**Cork County Council****Planning and Development Act 2000 (as amended)****Planning and Development (Strategic Infrastructure) Act 2006**

Planning Authority submission on further information received by An Bord Pleanála.

| <b>An Bord Pleanála Ref. No:</b>   | ABP Ref. 312606-22  |
| <b>Applicant:</b>                  | Ballinagree Wind DAC  |

Drawing file: P2114_Planning Drawings / 05843-DR-009_Ducting through Regional & Public Road Reinstatement.pdf

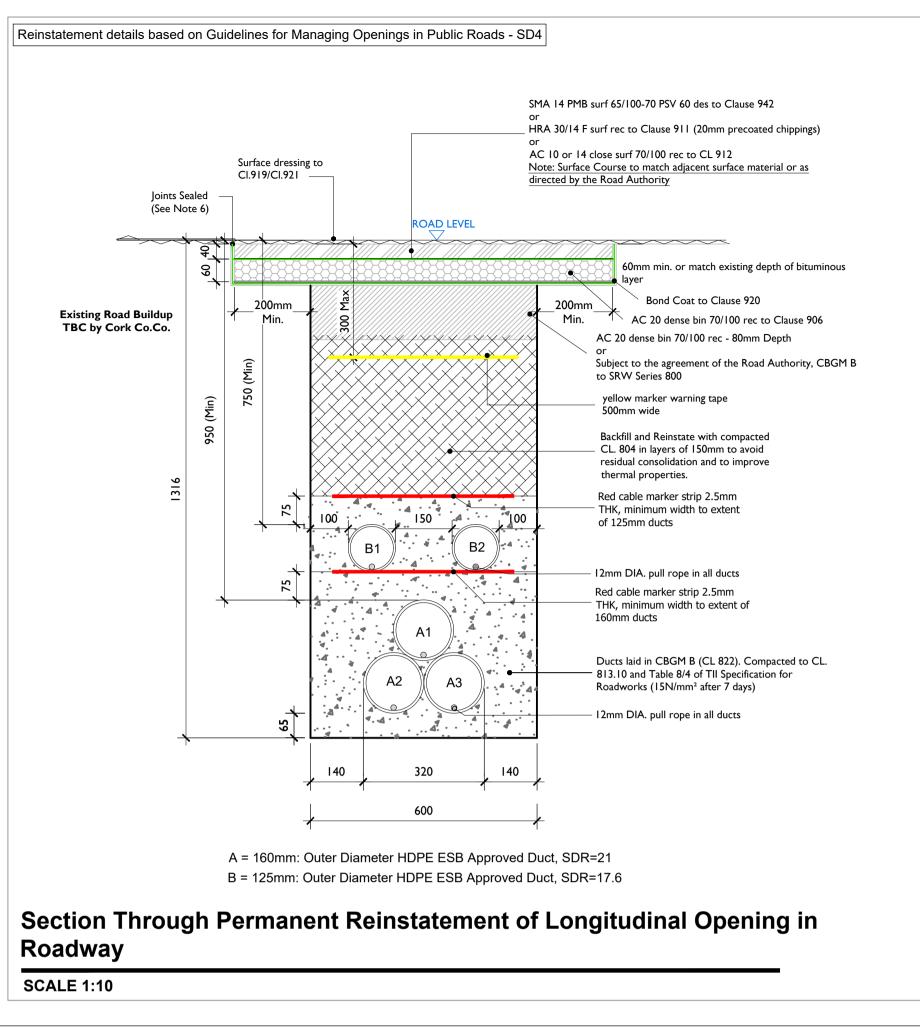
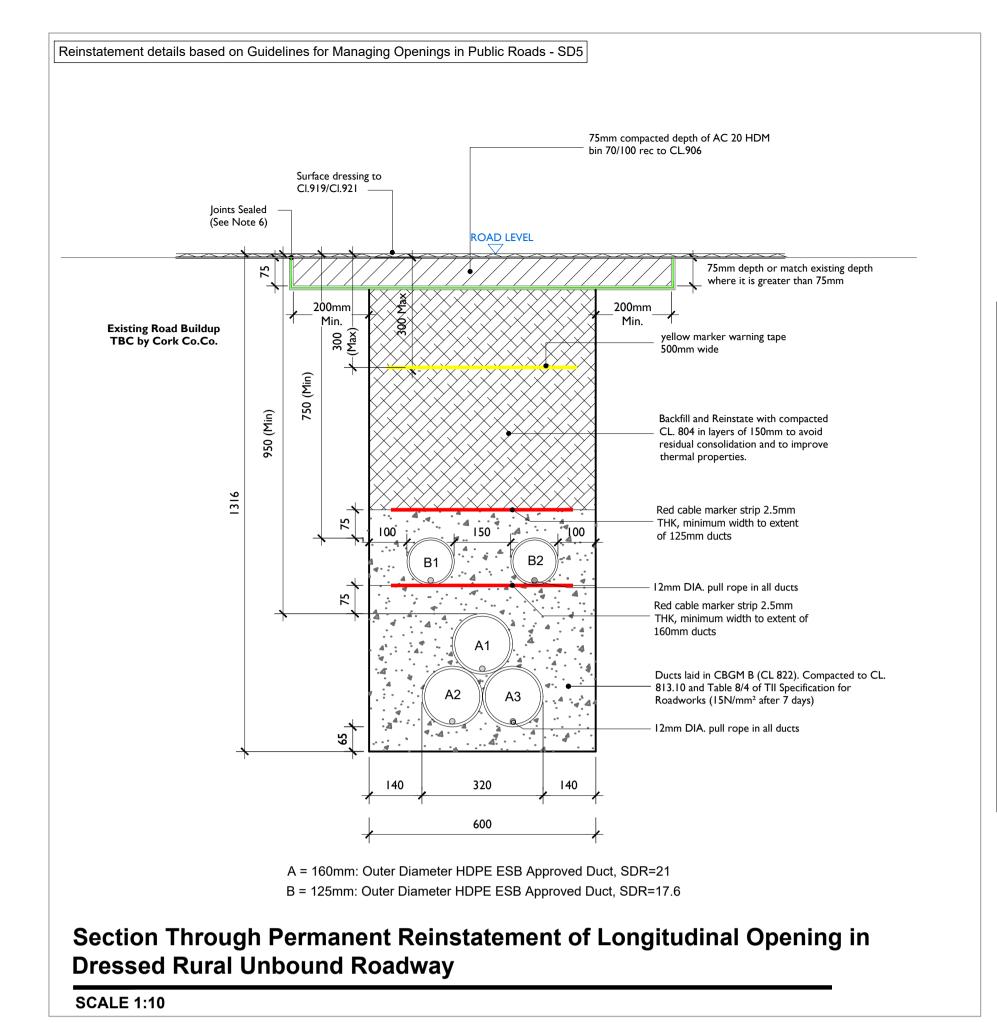
The applicant has responded saying that on two lane routes where the cable is being installed that they will reinstate the trench.

Experience of previous windfarms on 2 lane roads where cable routes are installed is that the second lane is used for moving plant and machinery while the first lane is being excavated. This results in the second lane being severely damaged. It then become virtually impossible to match in the trench reinstatement to the road surface in a satisfactory manner. For this reason:

It is recommended that all roads where the cable route is installed shall receive full road width regulating and resurfacing. Surface dressing alone will not suffice. The resurfacing type shall match existing surfaces.
